PRO TRANS PLUS VARIANCE OF USE SITE PLAN

LEGAL DESCRIPTION: LOT 17, BLOCK 1 MEADOW LAKE AIRPORT FILING NO 3

ADDED
VA253

# PRO TRANS PLUS VARIANCE OF USE SITE PLAN

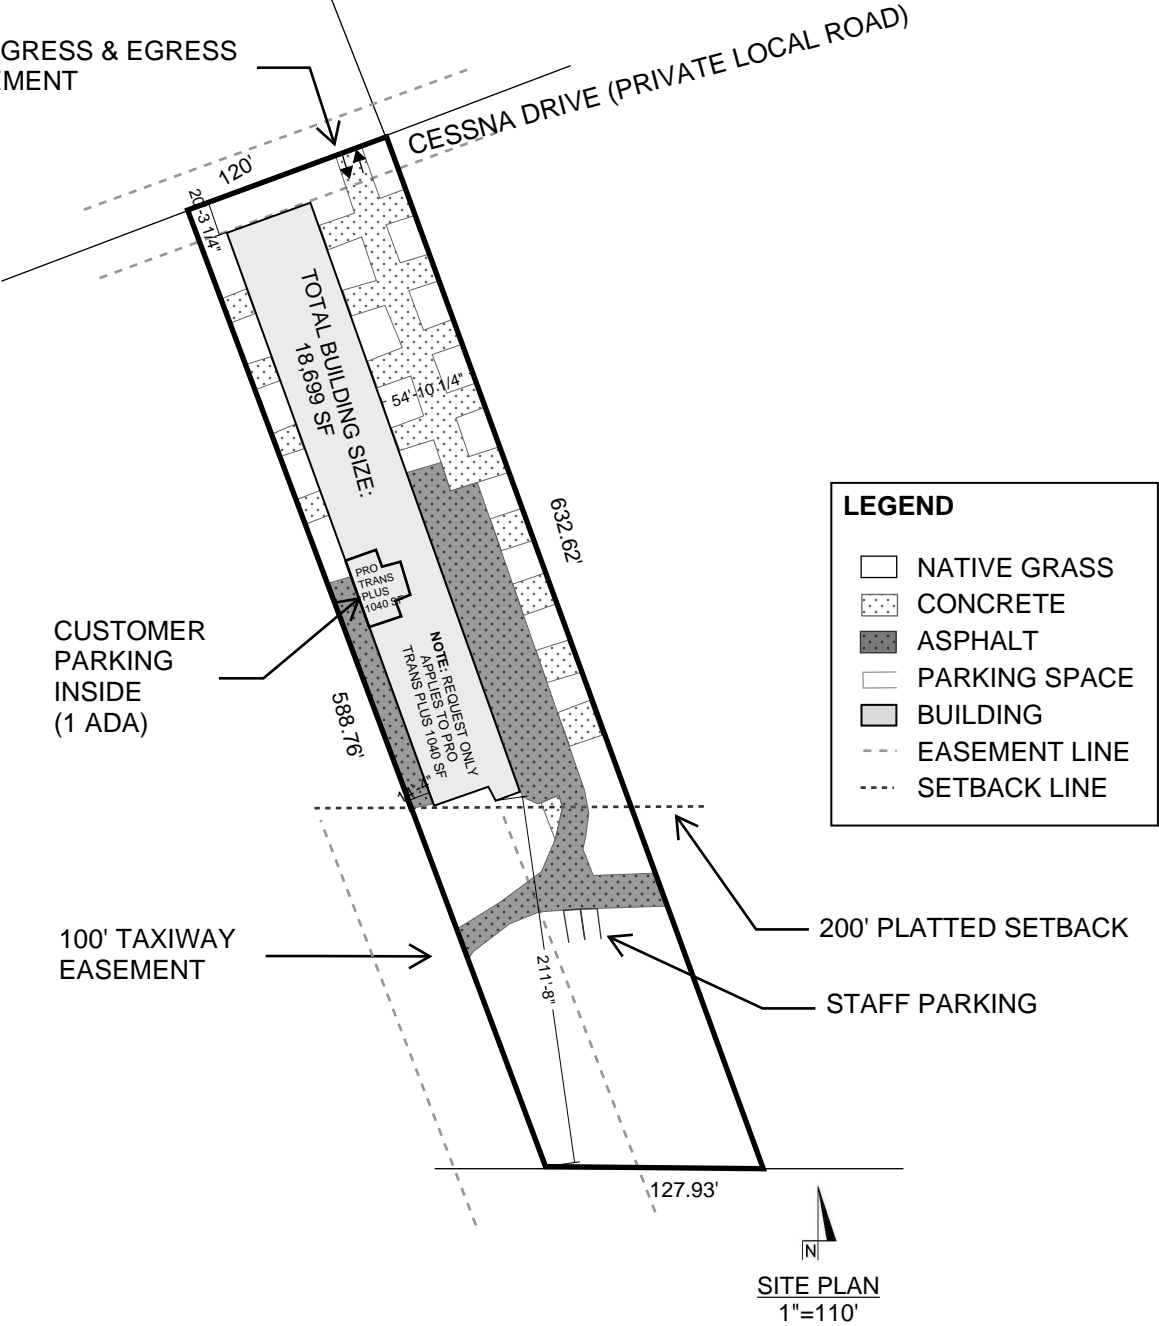
LOI states 2 employees, so 2 + 6 (for bays)+ must have 1 ADA space for a total of 9 spaces

See comments on LOI regarding customer parking.

- Please include:
- The setbacks of all building footprints dimensioned from all property lines **ADDED**
 - Dimensions of all property lines **ADDED**
 - Height of building **ADDED**
 - The location of all ADA parking space **ADDED**
 - Location of all no-build areas, floodplain(s), and drainage facilities (if none, provide a note to specify) **ADDED**
 - Location of dumpster **THERE IS NO DUMPSTER ASSOCIATED WITH THE VARIANCE OF USE**
 - Percent of open space and landscaping **LOT COVERAGE IS ALREADY INCLUDED NEAR THE TOP OF GENERAL NOTES**

REVISED. ALSO ADDED NOTE FOR ALTERNATIVE PARKING REQUEST

RESPONSE: 6 SPACES INSIDE SITE PLAN SPECIFIES 1 ADA SPACE
